Date: 2/8/2024

Project Name: Wiyada Sorkaew

Address: 1153 Christian Light Rd Fuquay-varina, NC 27526

The following changes were made at time of install:

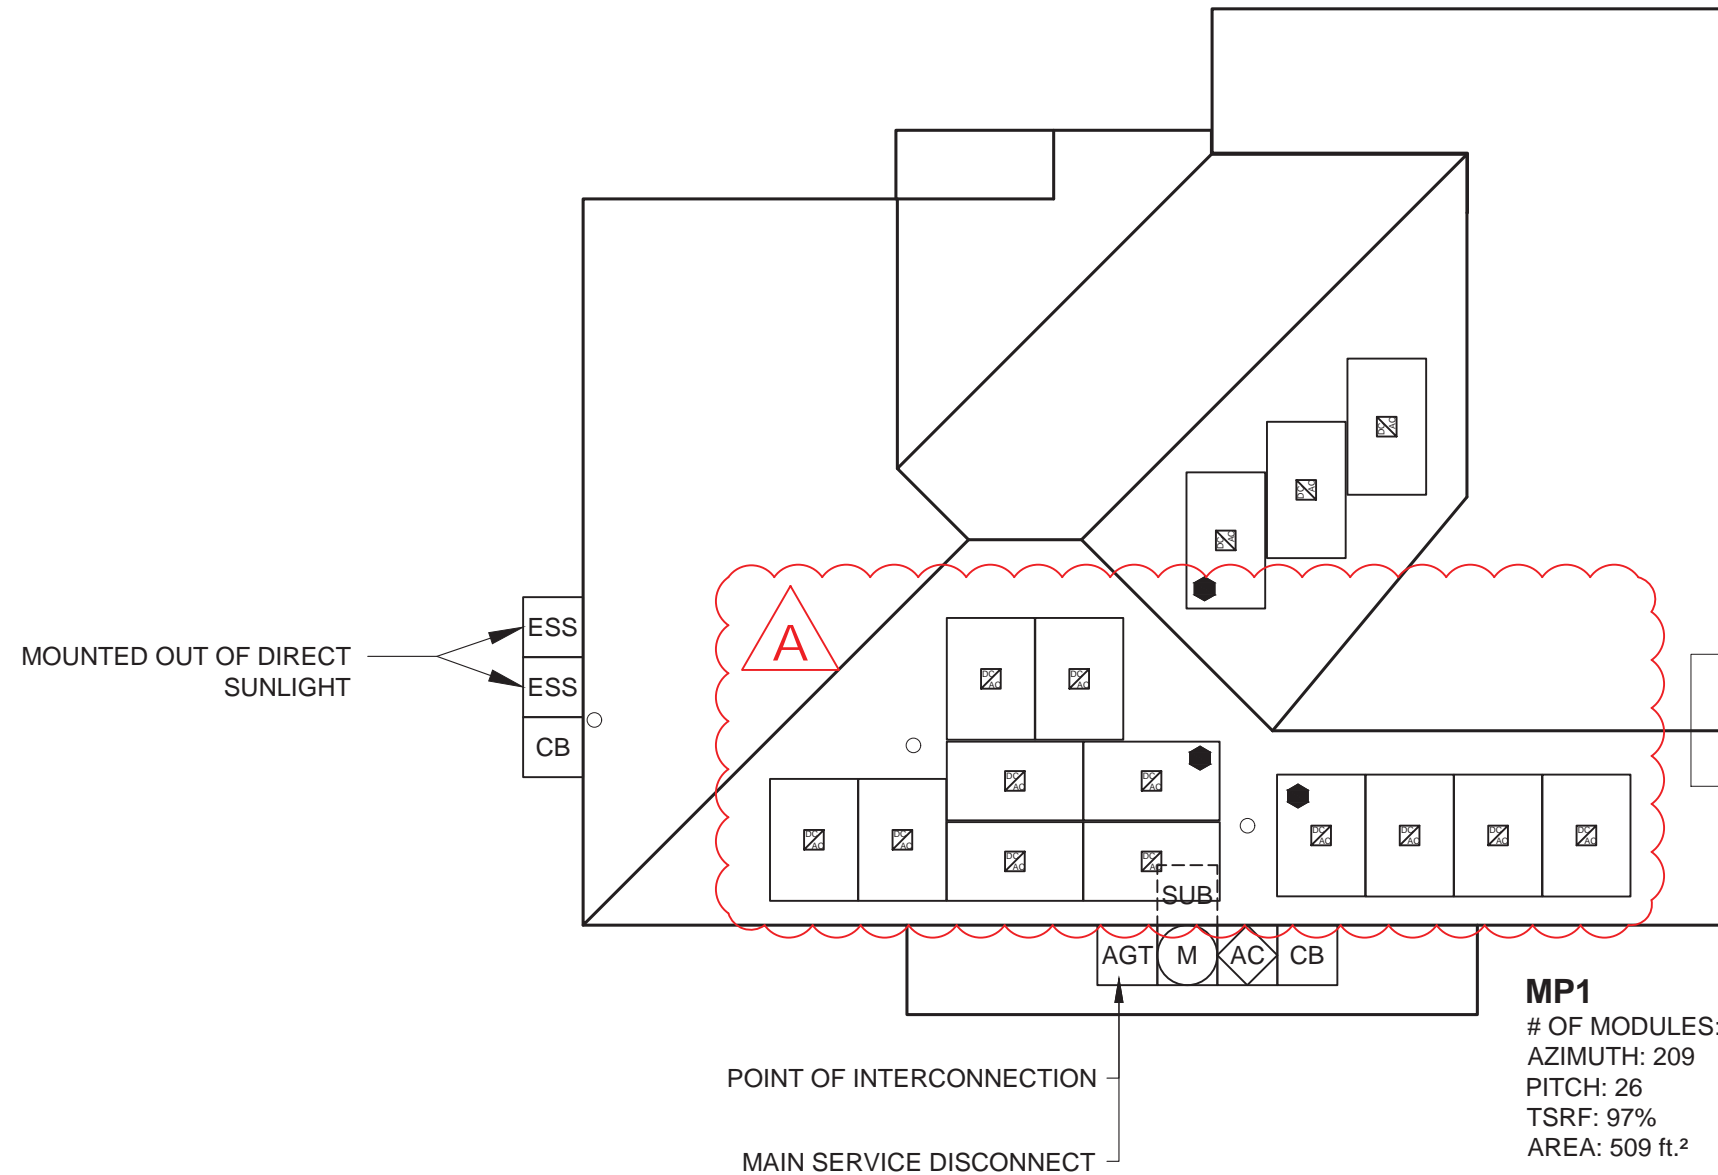
1. Updated module layout of MP1 and MP2
2. Conductor sizes changed for wire schedules #10 & #11.
